Reference No:	2025/62/93287/W
Site Address:	19, Smithy Way, Lindley, Huddersfield, HD3 3ZD
Description:	Erection of single storey rear and side extension
Recommending Officer:	Morgan Braithwaite

DECISION – Conditional Full Permission

OFFICER REPORT

1 02b GF Proposed
1 : 100

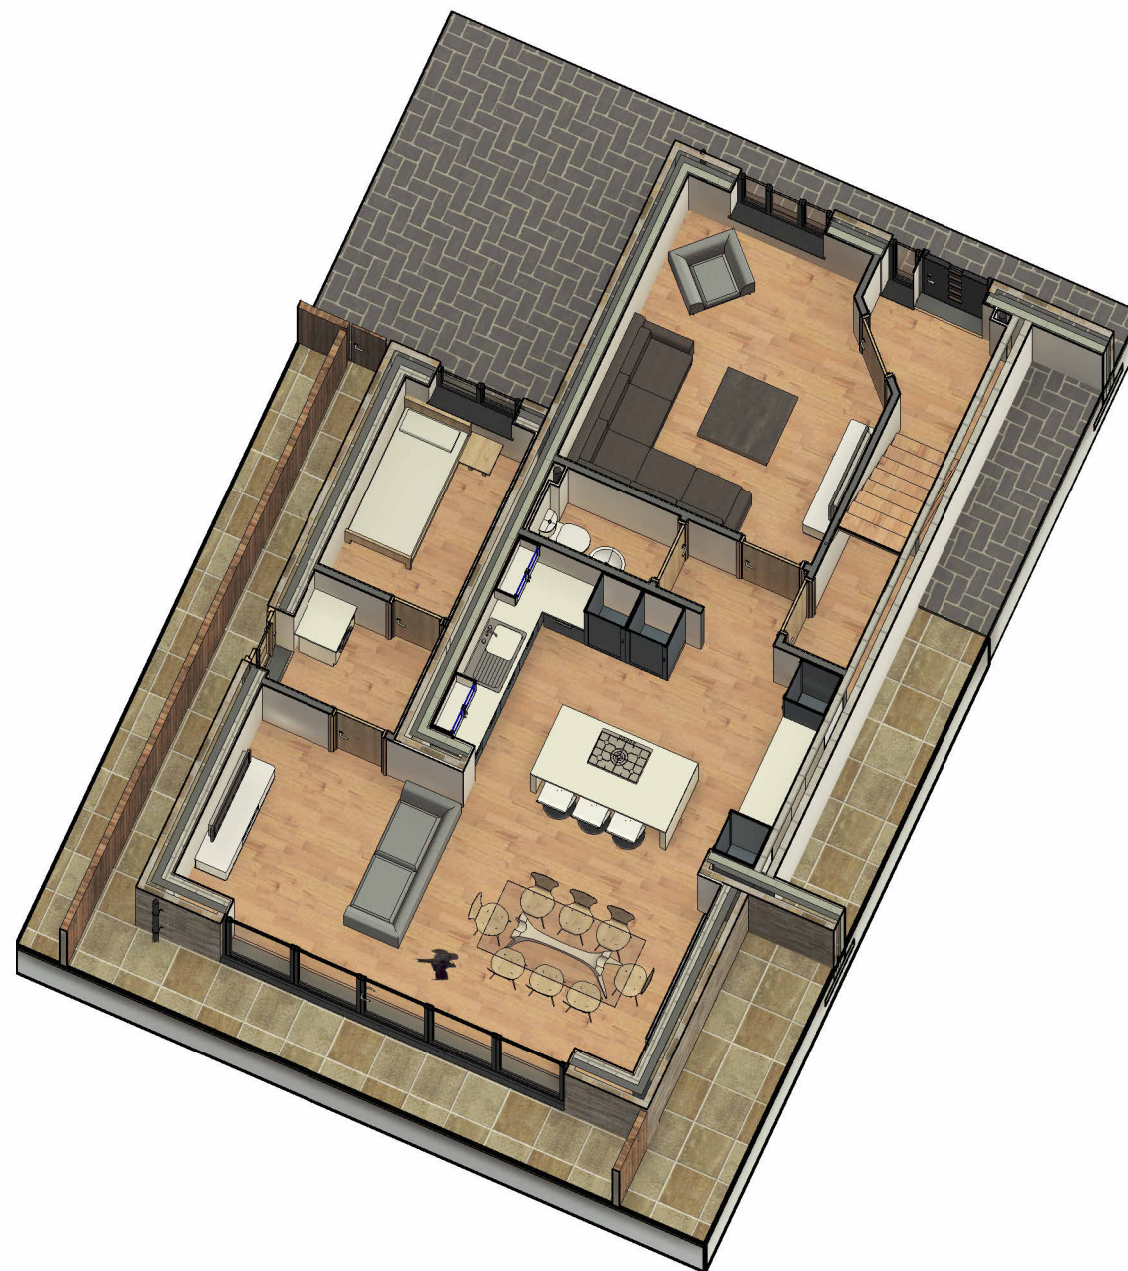
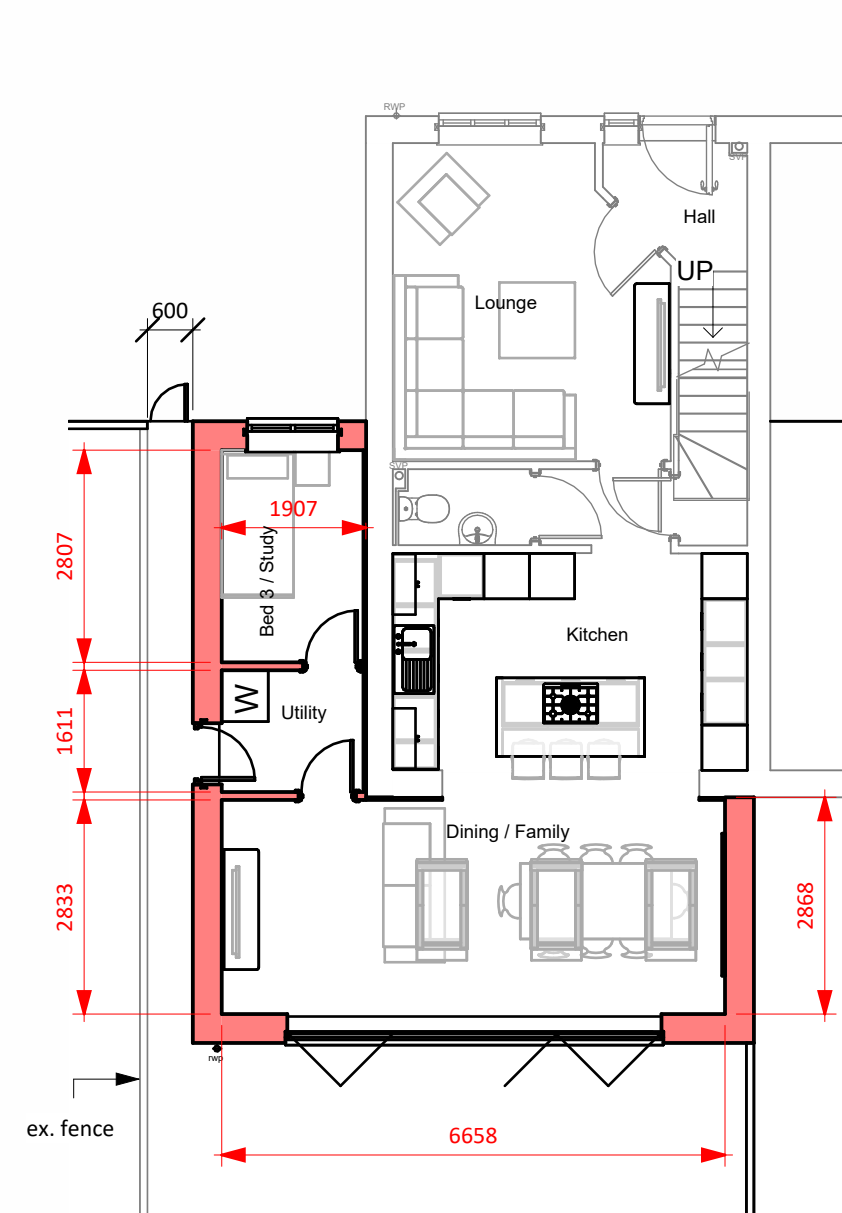
- Boundary concerns and inaccuracies in the submitted plans – The submitted plans suggest that the existing boundary treatment is to be removed and replaced with the extension wall.
Officer response: This concern was discussed with the agent, who explained that the boundary fence is not to be removed. Amended plans have been submitted to show the boundary fence still in situ.

- Required one-metre gap
Officer Response: The amended plans show the proposed rear extension to be set in from the boundary, however this would be by less than 0.5m. Whilst the Council's House Extensions and Alterations SPD advises that extensions should be set in by 1.0m from the shared boundary, the potential impact of the proposal in this case as a result of the proposed arrangement is not considered to be so significant to warrant refusal of the application for the reasons already set out above.

Kirklees Development Management Charter together with the National Planning Policy Framework and the DMPO 2015 encourages negotiation/engagement between Local Planning Authorities and agents/applicants. Amended plans were submitted following concerns raised in representations. These showed the proposal to be set in from the shared boundary, instead of being sited on the boundary line replacing the existing retaining wall.
